DRB CASE ACTION LOG (SITE PLAN FOR BUILDING PERMIT)
REVISED 9/28/05

DRB Application No.: <u>07DRB-70196(SBP)</u>	Project # <u>1005484</u>
Project Name: <u>RIVERVIEW PARCELS</u>	
Agent: <u>MULLEN HELLER ARCHITECTURE PC</u>	Phone No: <u>268-4144</u>

**City of Albuquerque
Planning Department
Inter-Office Memorandum**

To: Sheran Matson, DRB Chair
From: Carol Toffaleti, Planner 
Date: August 21, 2007
Subject: Project # 1005484 / 07EPC-00433 – Golf Course Rd.

sheet title  
**Site Development Plan for Building Permit**

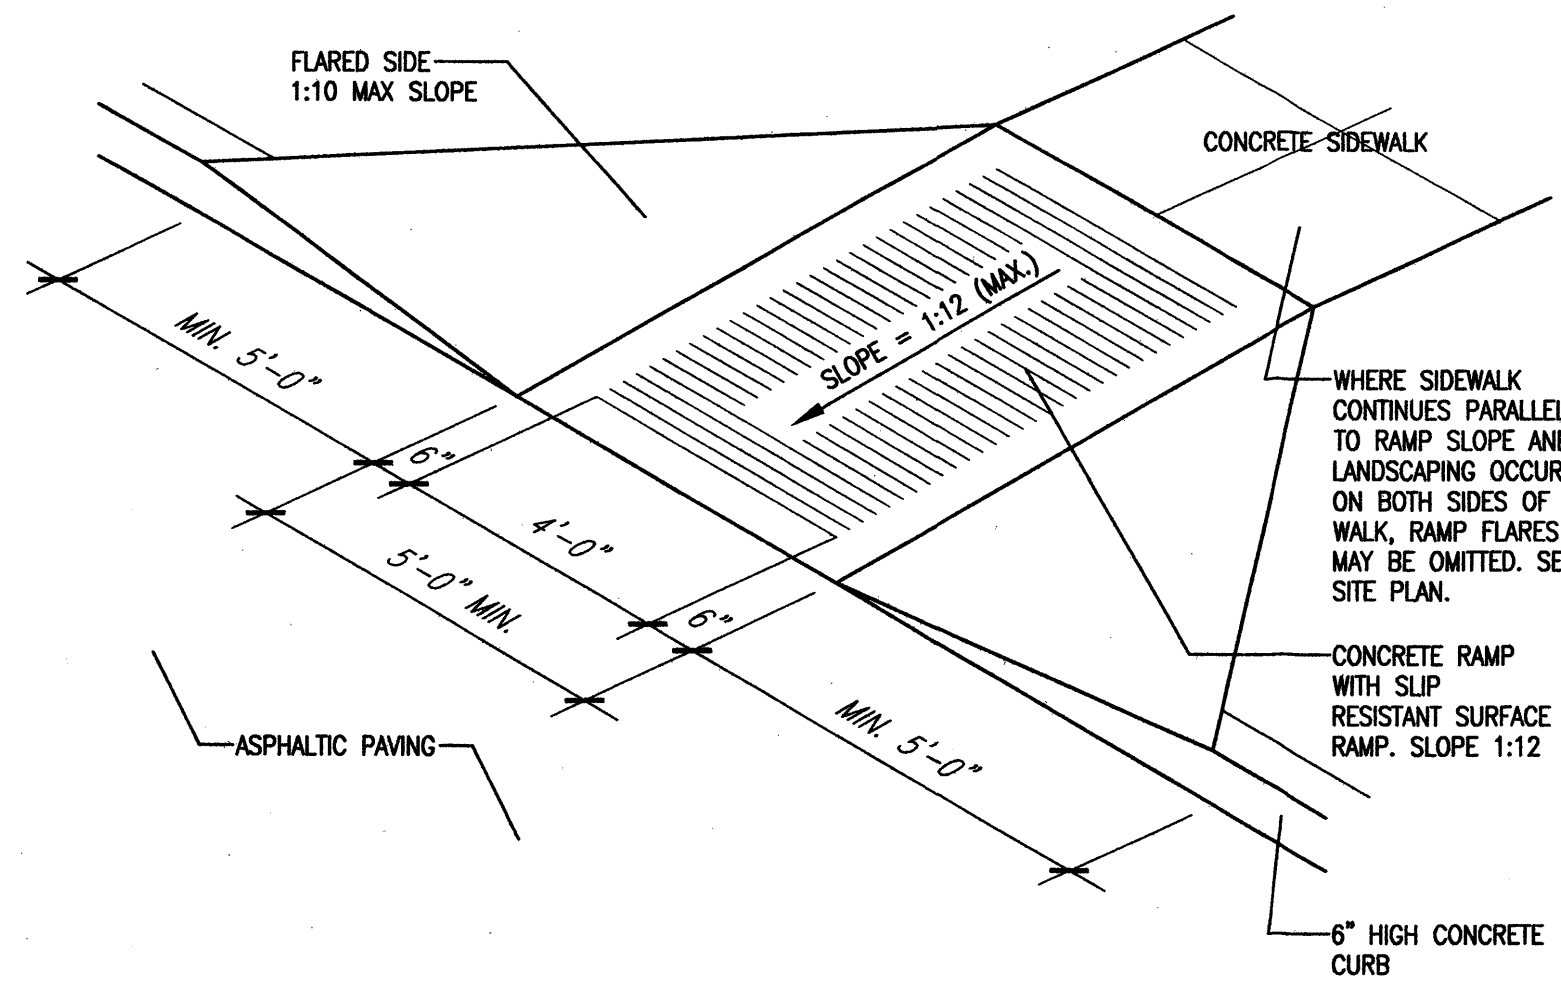
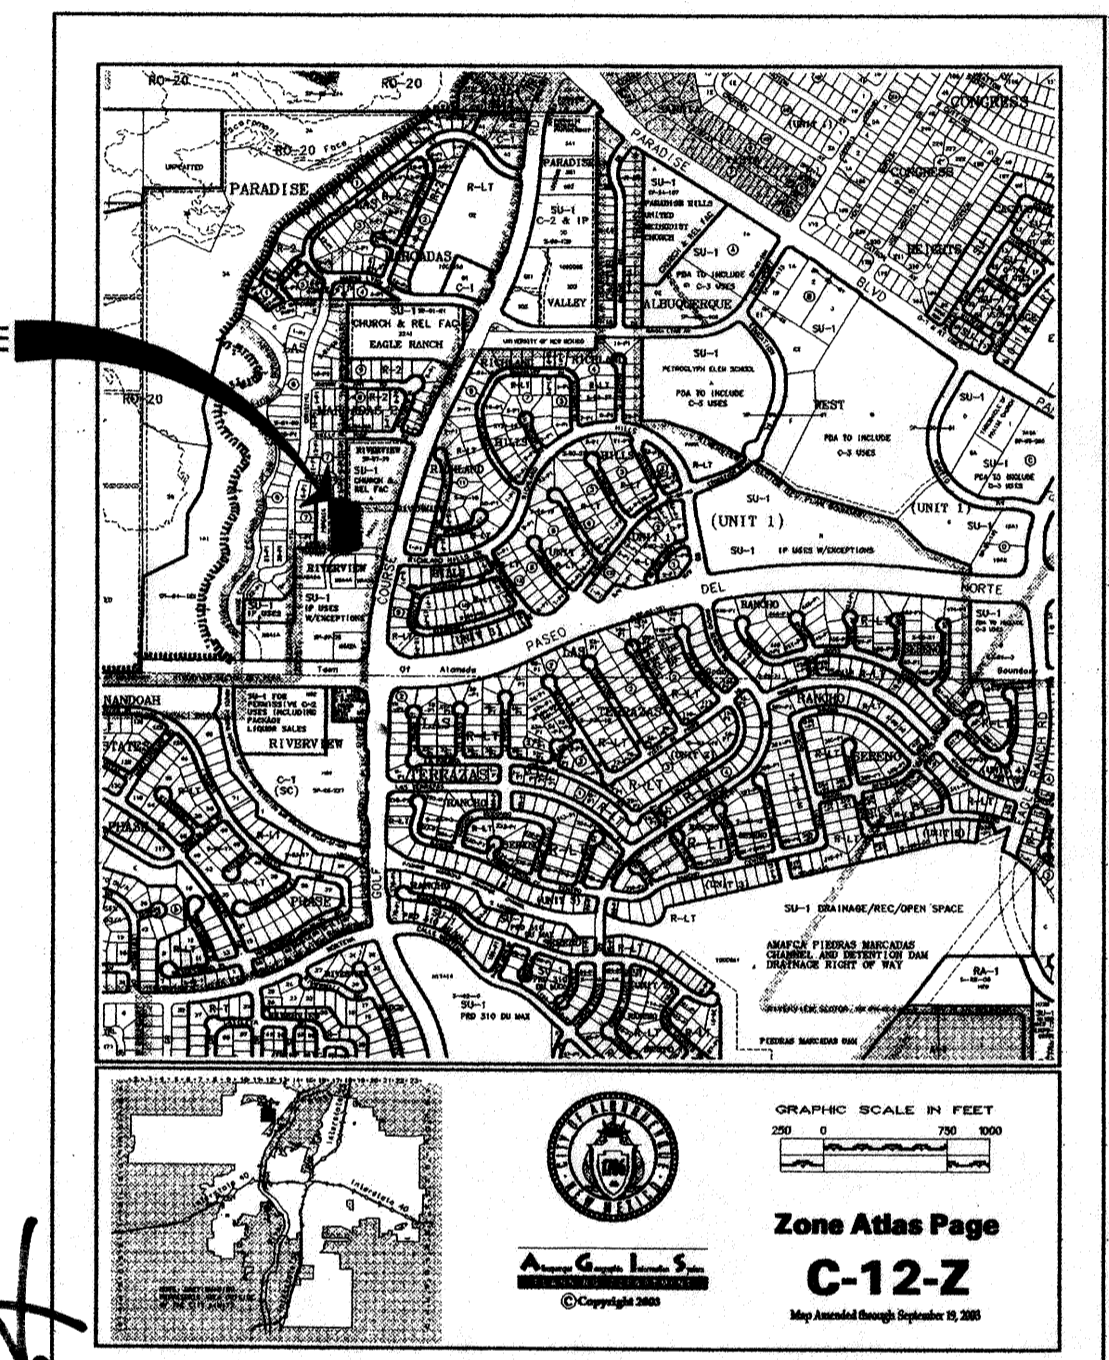
- 1) Why isn't the full 30' access easement being paved?
 (Note 28)
- 2) A copy of the plat that provides cross-access is
 needed.
- 3) Are the sidewalks within public easements?

3. Zoning designation

The AGIS system indicates that the lot is currently split between two zoning designations, SU-1 for IP and "SU-1 for for uses permissive in IP with exceptions". In doing the case history research, Staff found that the entire lot should have the second designation (see attached excerpt from EPC case report) and will undertake to have the zone map reflect the correct zoning.

For clarity, Staff has asked the applicant to indicate on the site development plan that the zoning designation is "SU-1 for uses permissive in IP with exceptions".

project title  
**Retail Pad Building**  
Northwest Corner of Paseo Del Norte and Golf Course Road  
Albuquerque, New Mexico  
sheet title  
**Landscape Plan**

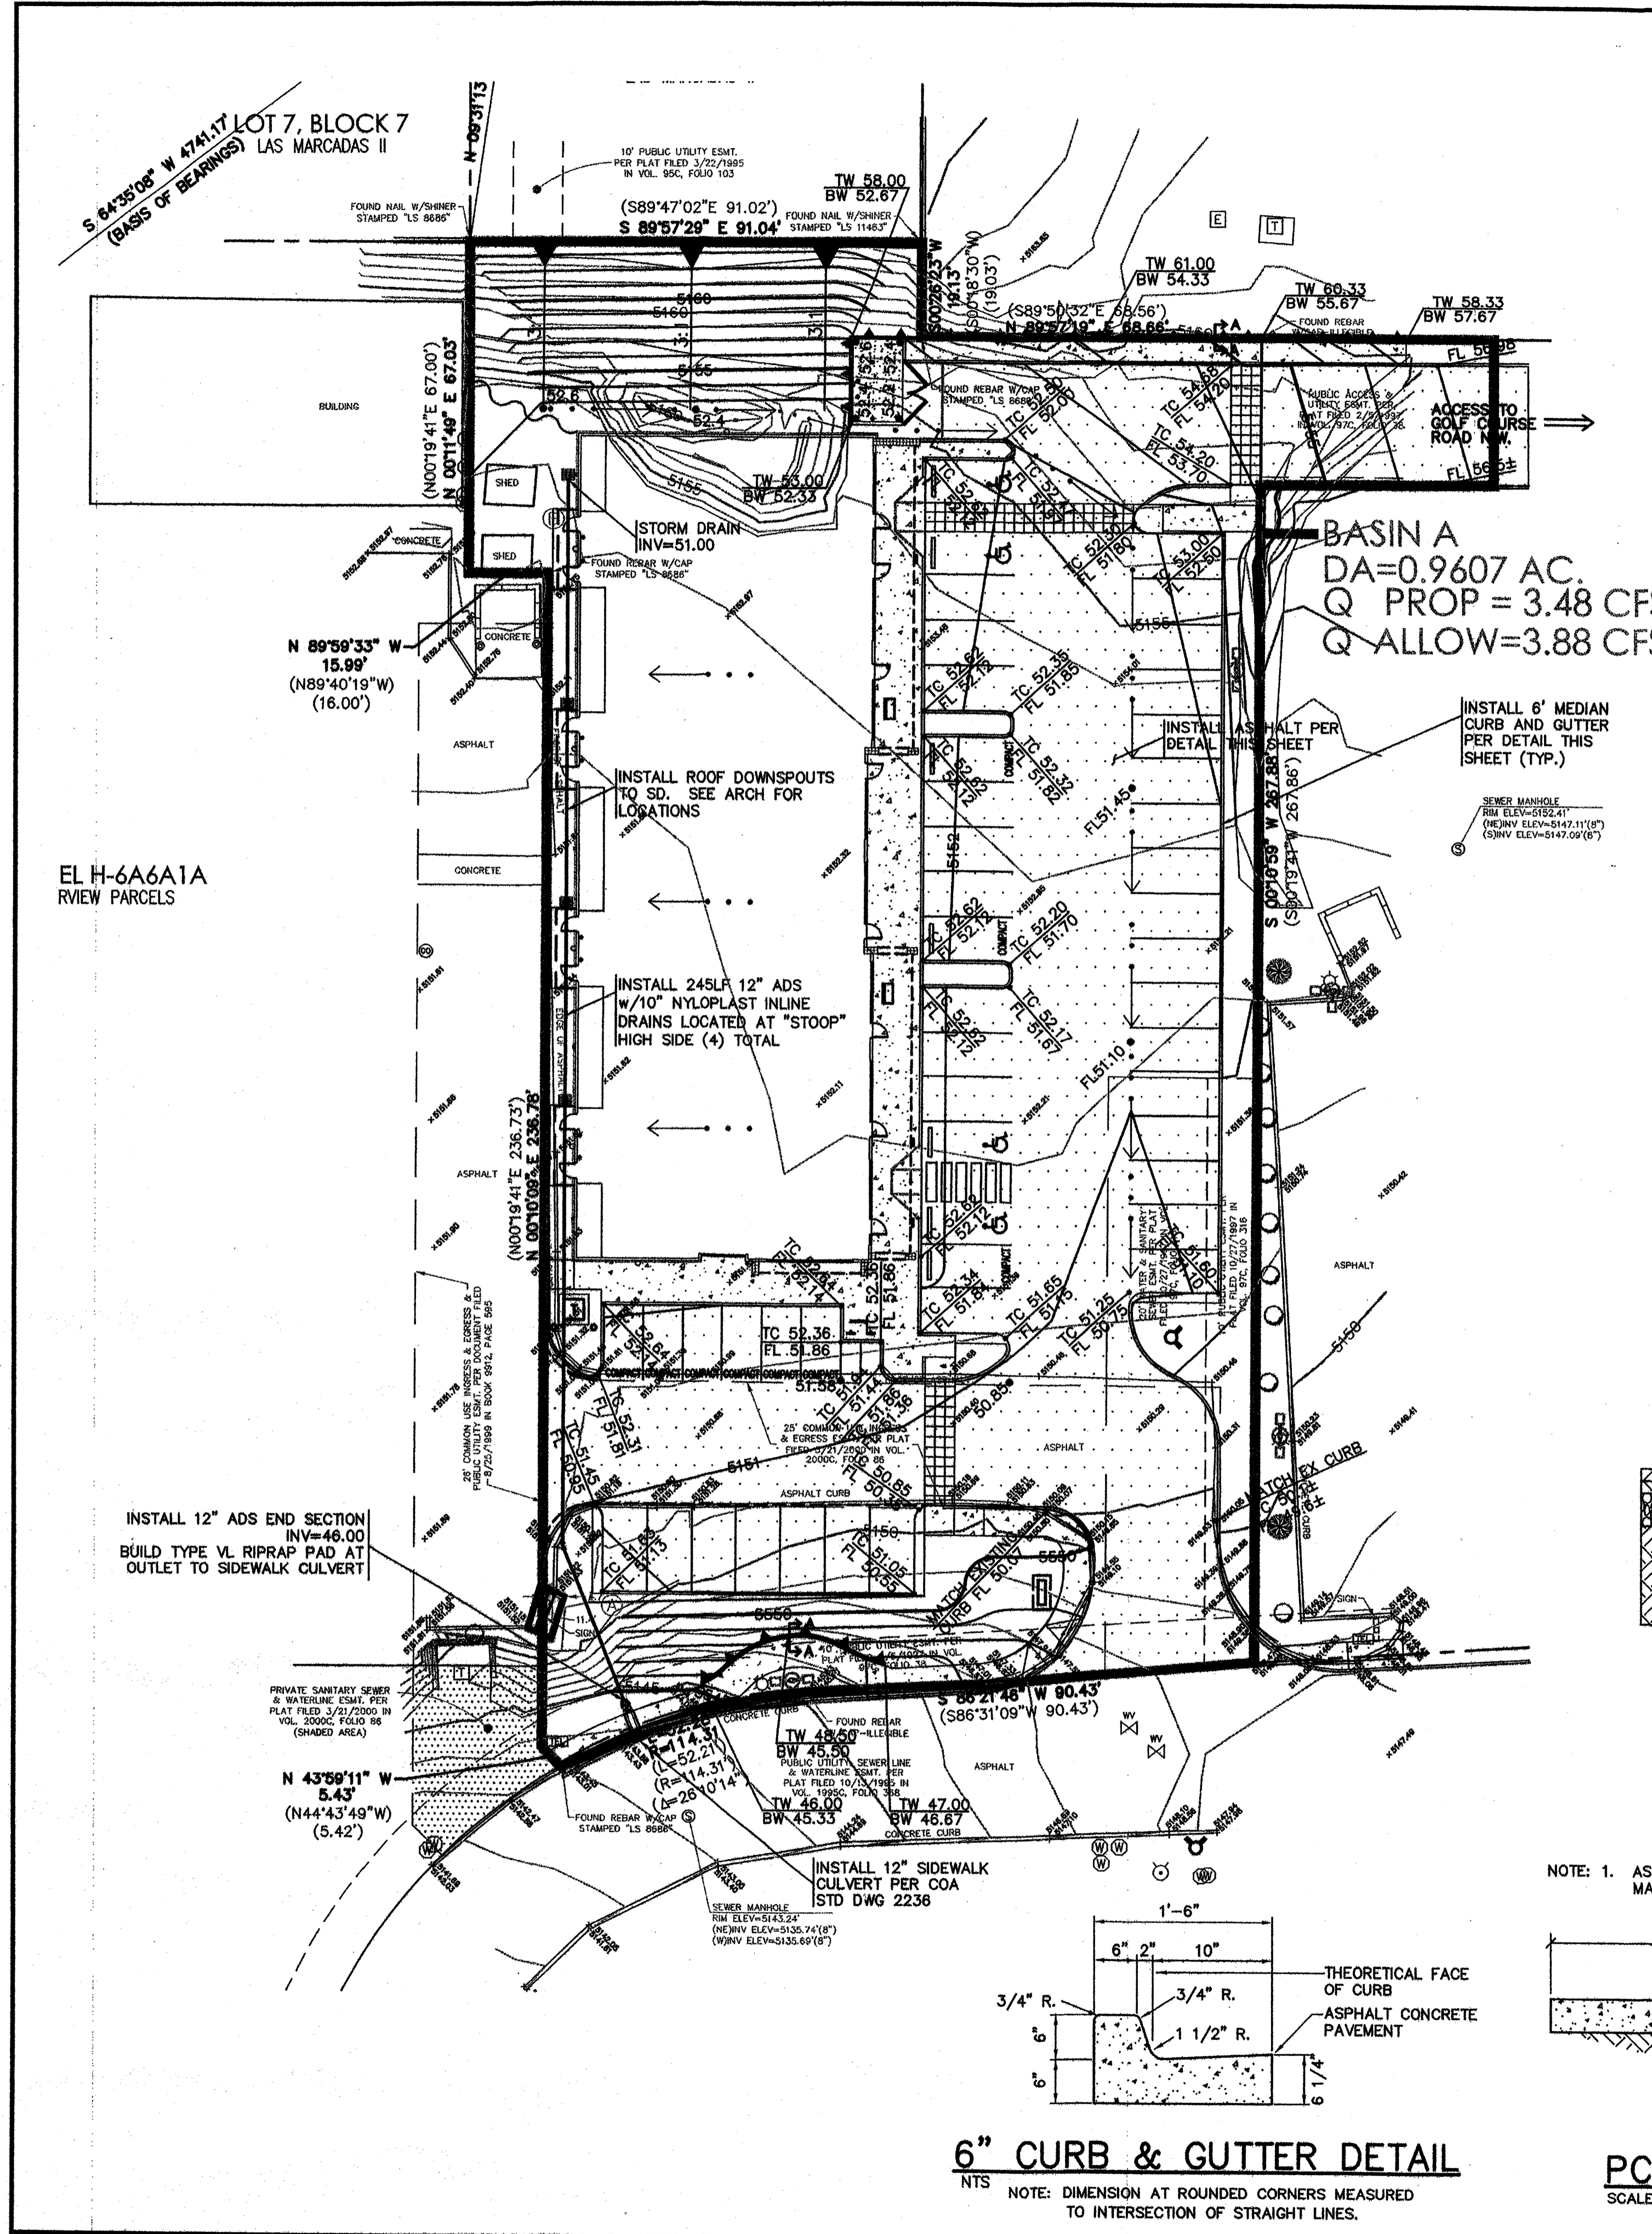
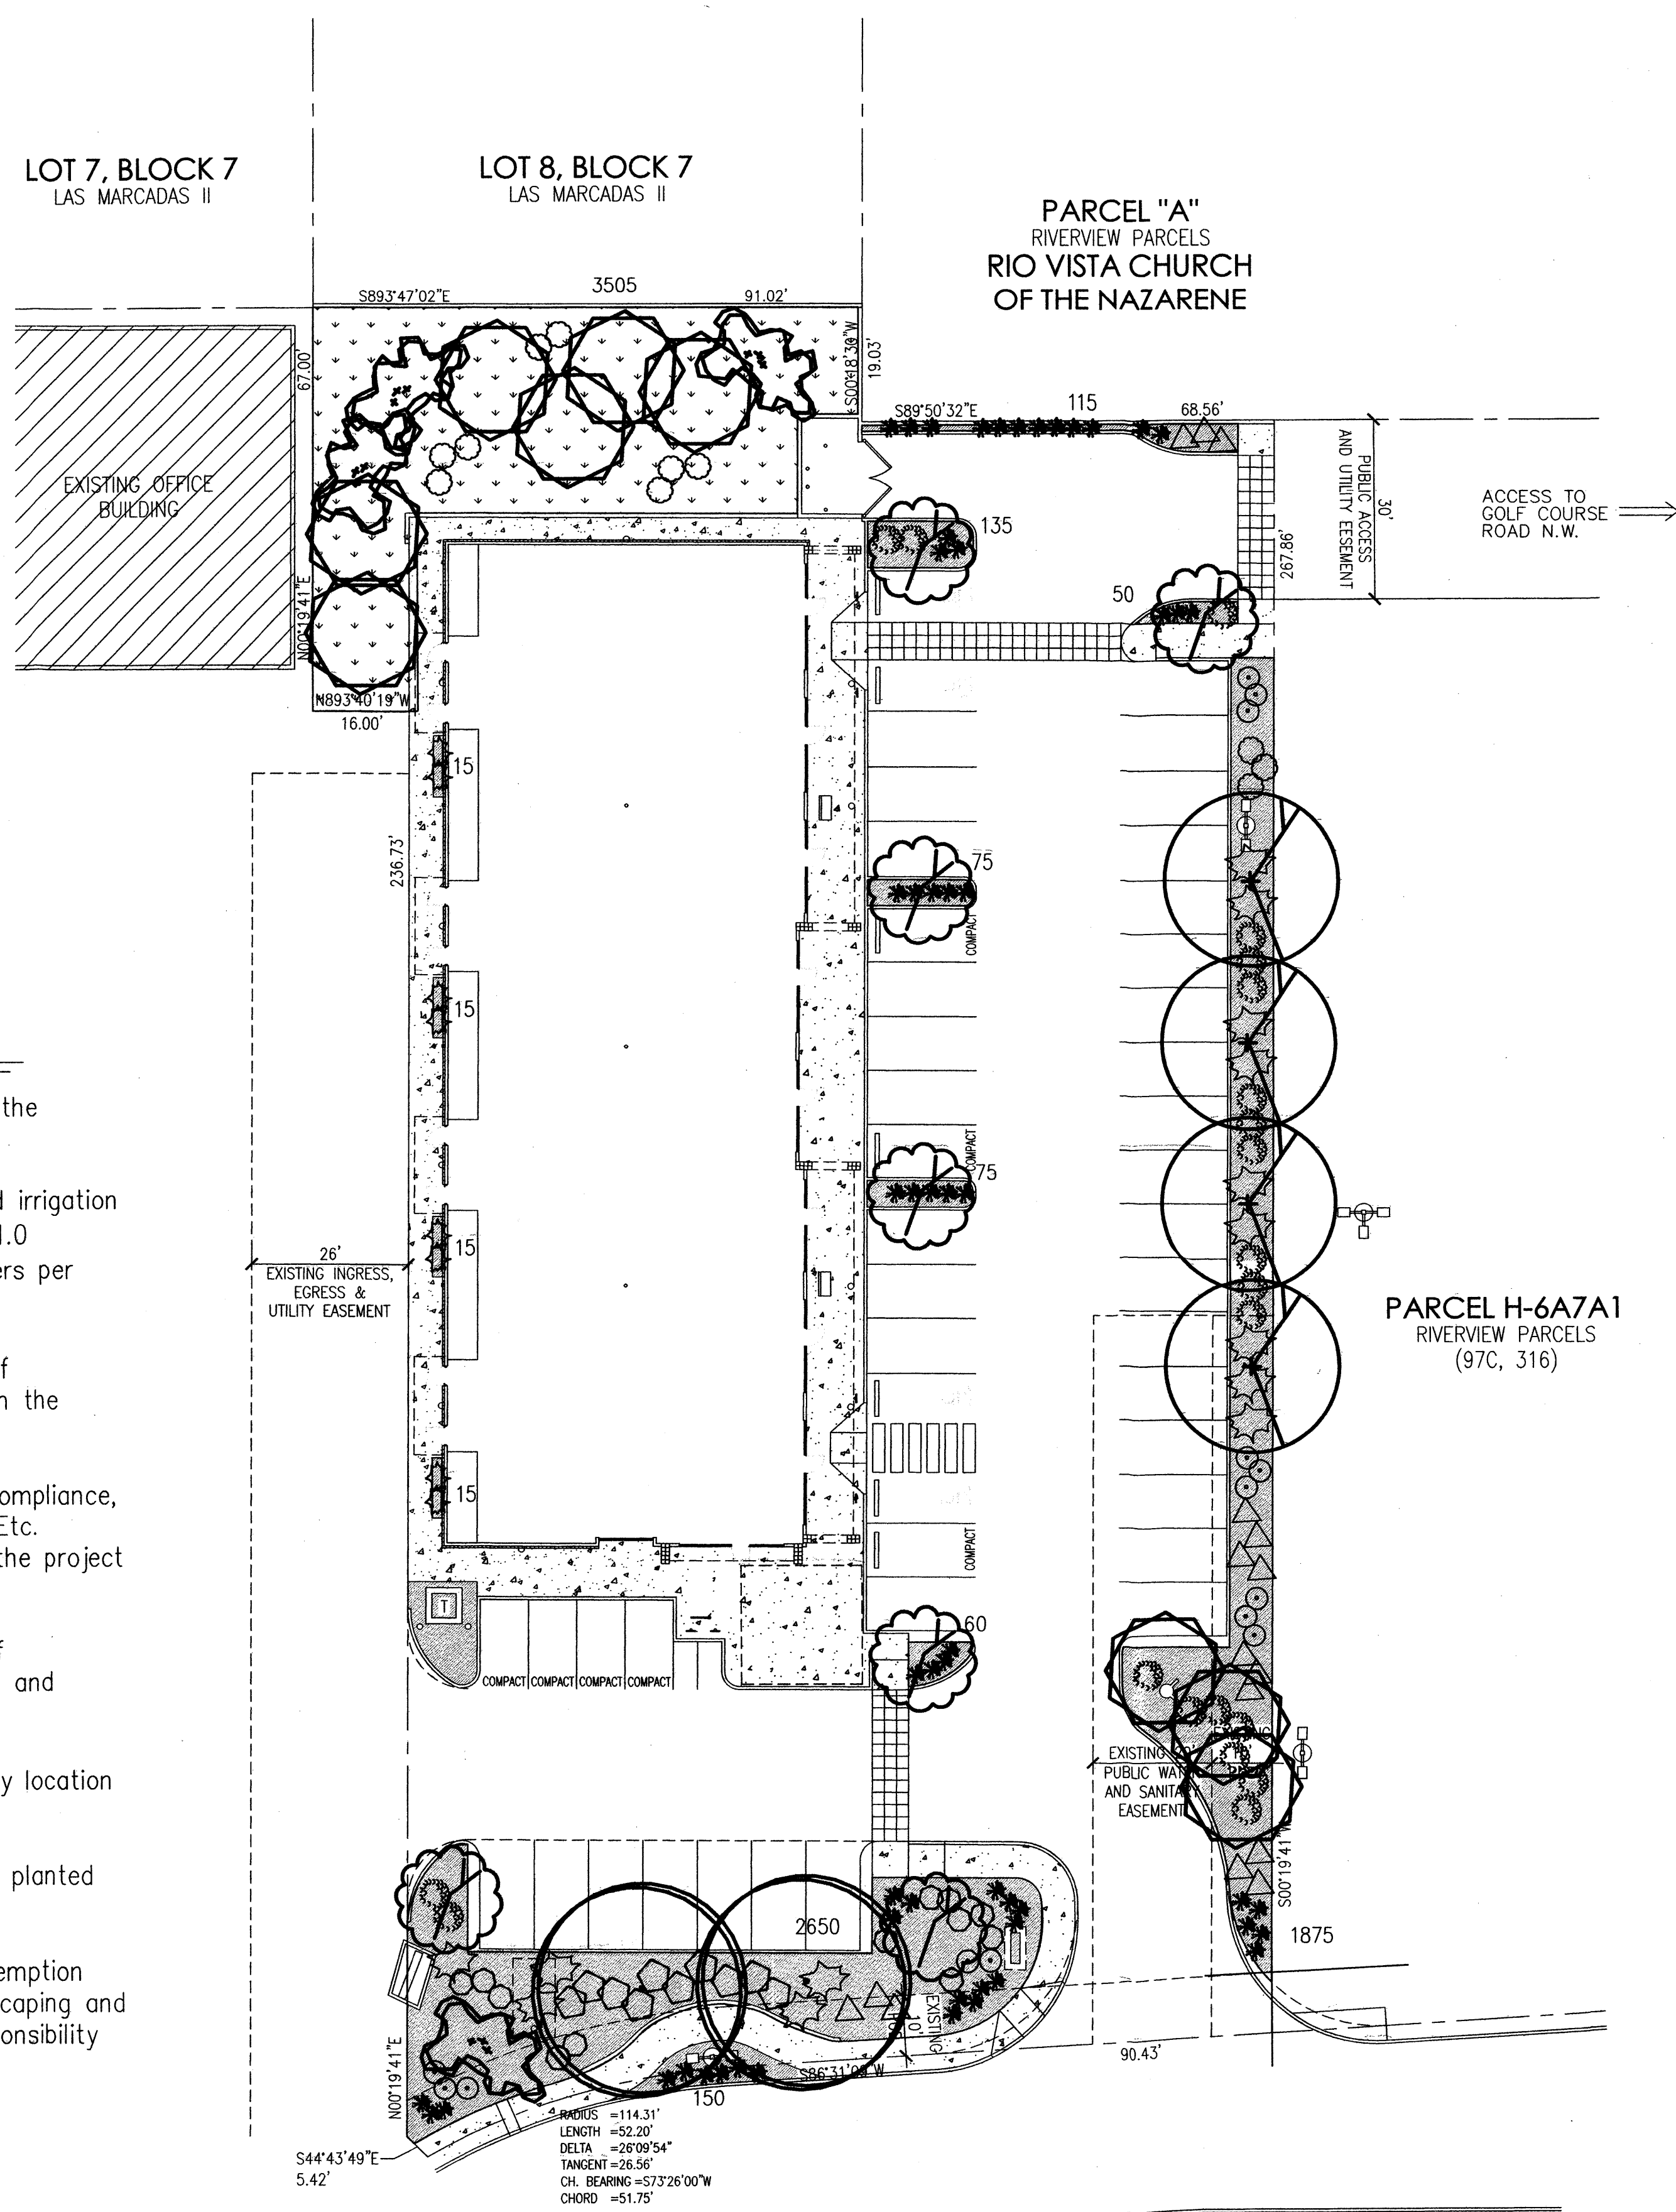
8. Landscape Plan

a. The plants listed are not all low water use plants ("L") and should be changed accordingly. Staff has asked the applicant to replace medium- with low-water use plants as per the condition, by replacing 3 Bradford Pear with 3 Desert Willow, and at least half the number of proposed shrubs and grasses in landscaped beds with more xeric plants, such as: Apache Plume, Rockrose, Big Sage, Fernbush, Beargrass, and Indian Ricegrass.
